**WELWYN HATFIELD BOROUGH COUNCIL
EXECUTIVE DIRECTOR - PLANNING, PUBLIC PROTECTION AND GOVERNANCE**

DELEGATED APPLICATION

Application No: 6/2018/0457/HOUSE
Location: 35 Carbone Hill, Northaw, Potters Bar, EN6 4PN
Proposal: Erection of first floor rear extension, roof alterations and 2no rear Juliet balconies following demolition of conservatory and outbuildings. Change of external materials, replacement windows and installation of new front access and exit gates
Officer: Mr David Elmore

Recommendation: Granted

[01] PROPOSED GROUND FLOOR PLAN

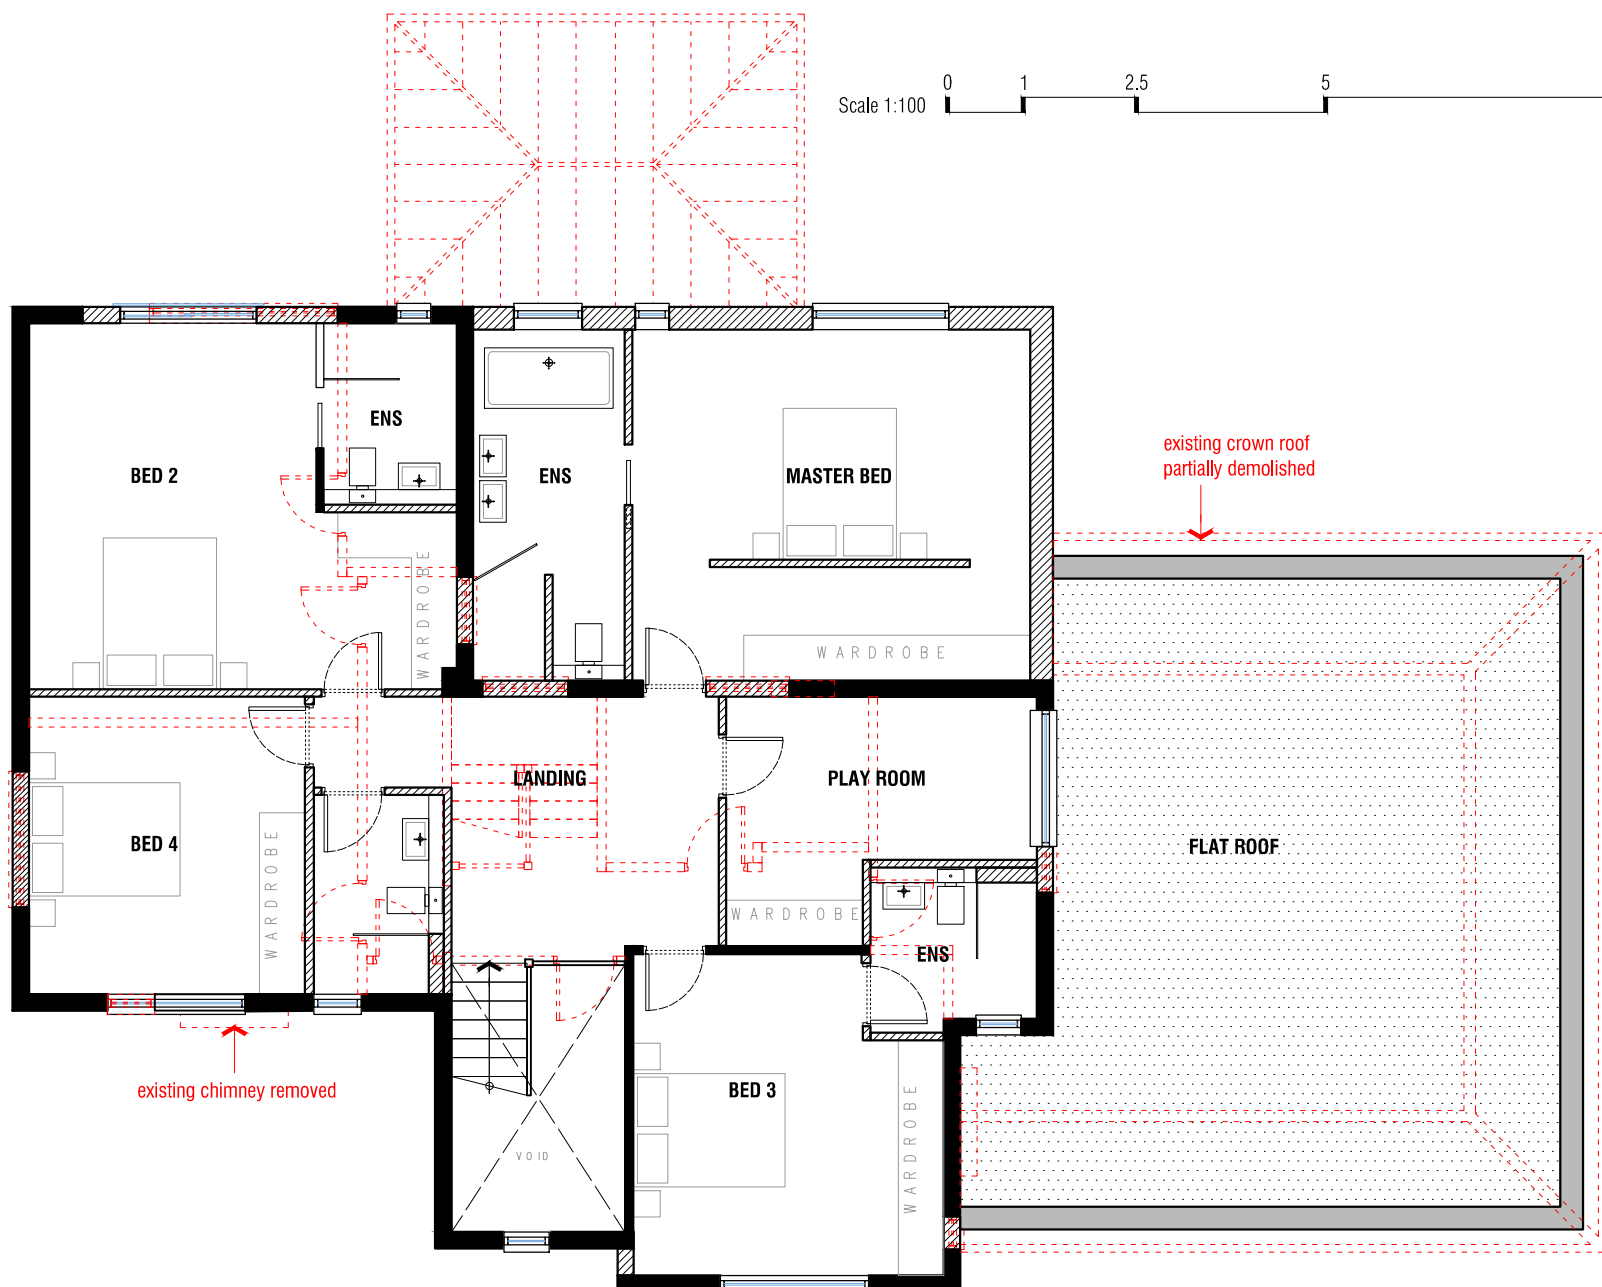
The proposed first floor extension would infill a gap above the existing living and kitchen area, creating a flush rear elevation at two-storey level and introducing 3no matching hipped roofs. The design of the proposed extension and subsequent alterations to the main roof would respect the style and form of the existing dwelling and having regard to its location to the rear, would not be visually prominent from the street-scene.

The crown roof of the attached single storey element of the building would be replaced by a flat roof with parapet. Also the modest pitched roof above the original entrance would be replaced by a flat roof. Such alterations would acceptability relate to the design and character of the dwelling.

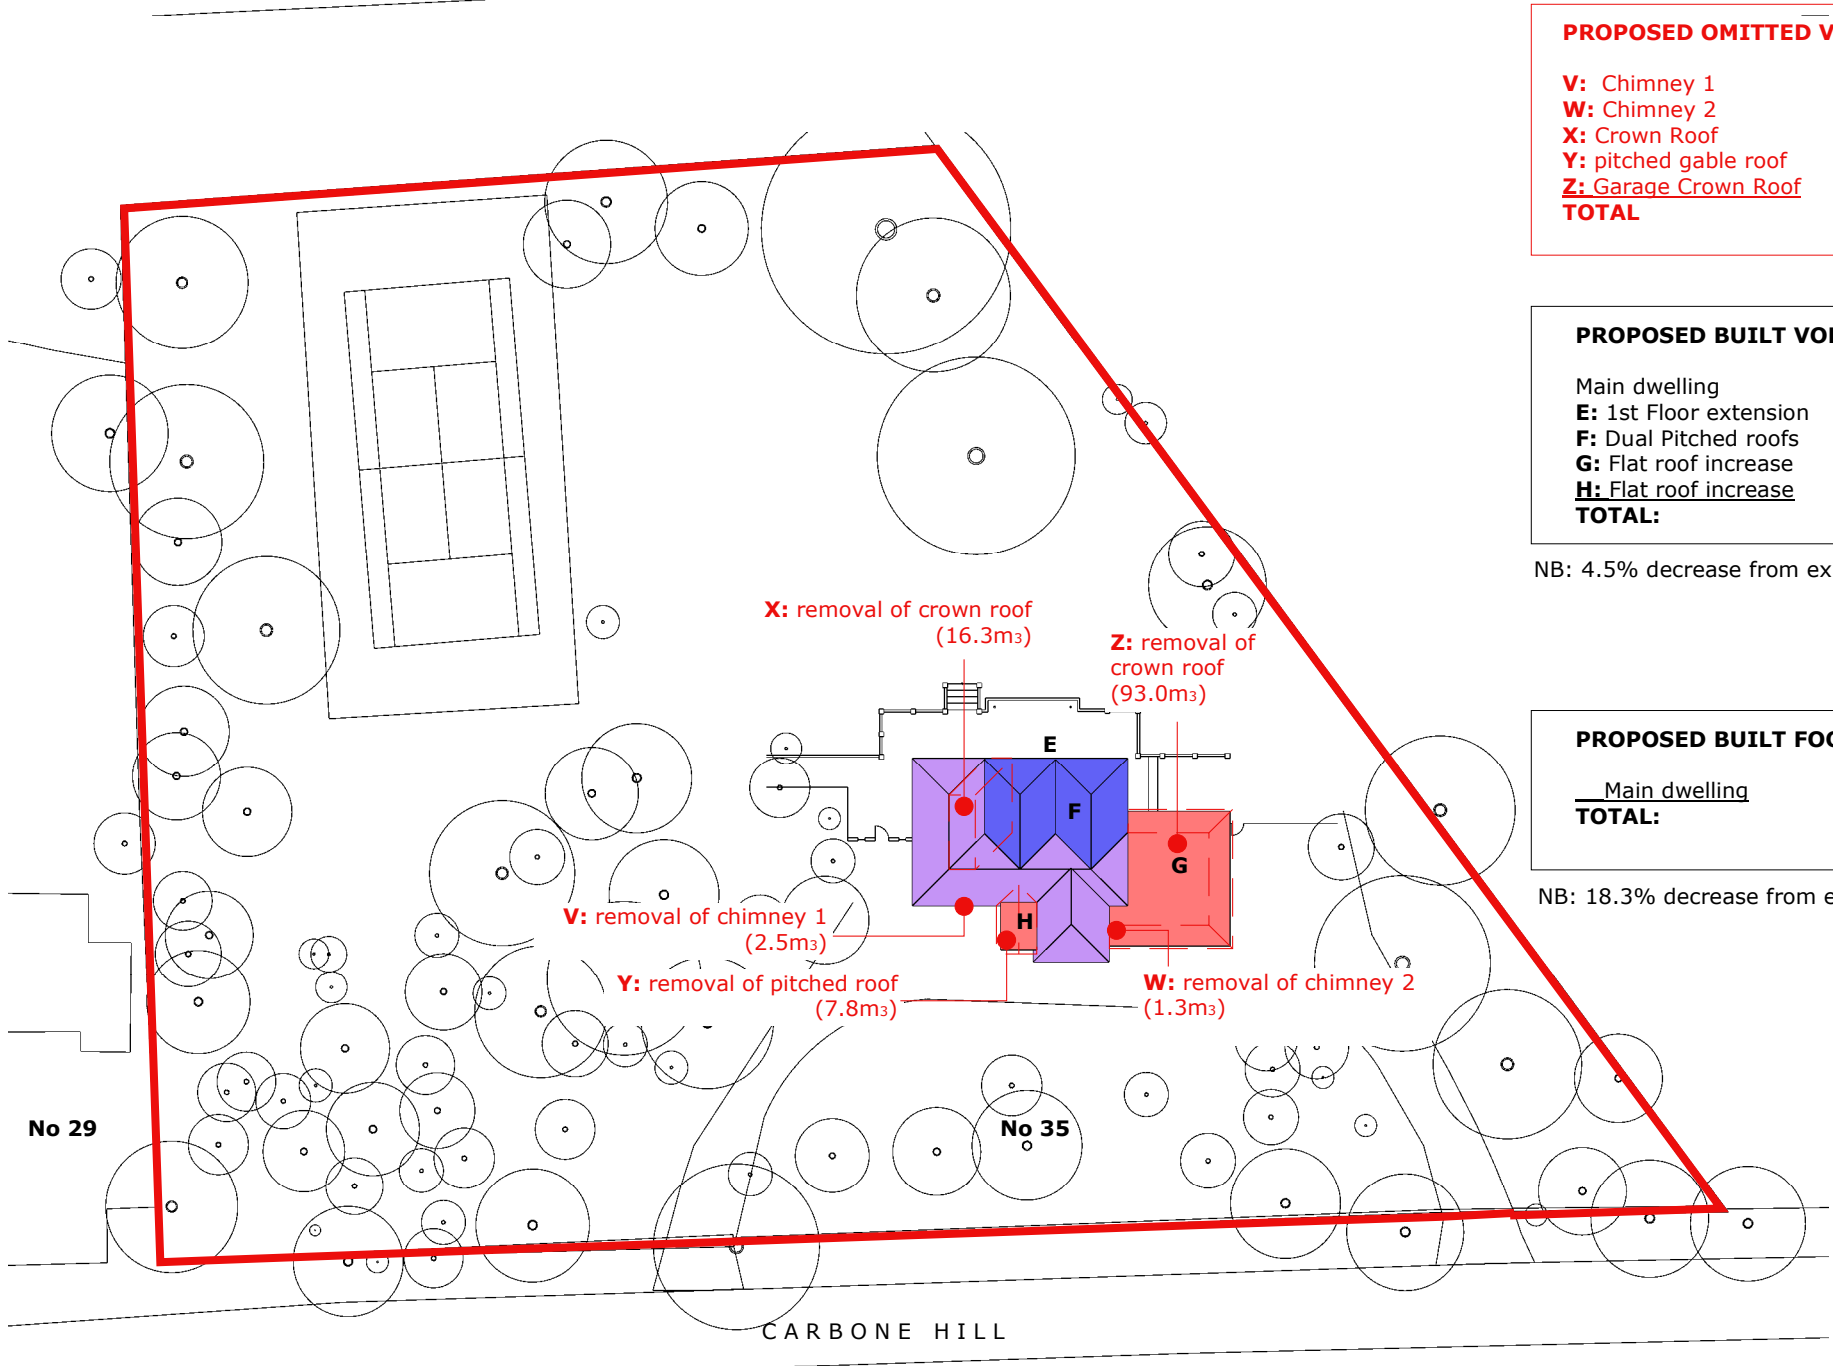
The existing dwelling (including chimneys and conservatory) has a volume of approximately 1172 cubic metres. The main addition to the dwelling would be through the proposed first floor rear ‘infill’ extension. The added volume and bulk created is proposed to be mitigated through the removal of crown/pitched roofs and 2no chimneys on the dwelling. As a result of the proposed extensions/alterations, the resultant dwelling would have a volume of approximately 1182 cubic metres.

Taking account of the above calculations, it is not considered that the proposed development would be materially larger in quantitative terms than the existing dwelling. Furthermore, the proposed extensions would be contained within the existing footprint of the dwelling and be read against the backdrop of the dwelling. Therefore, it is considered that the proposed development would not harm openness. Overall, it is considered that the proposed extensions to the dwelling are acceptable in Green Belt terms.
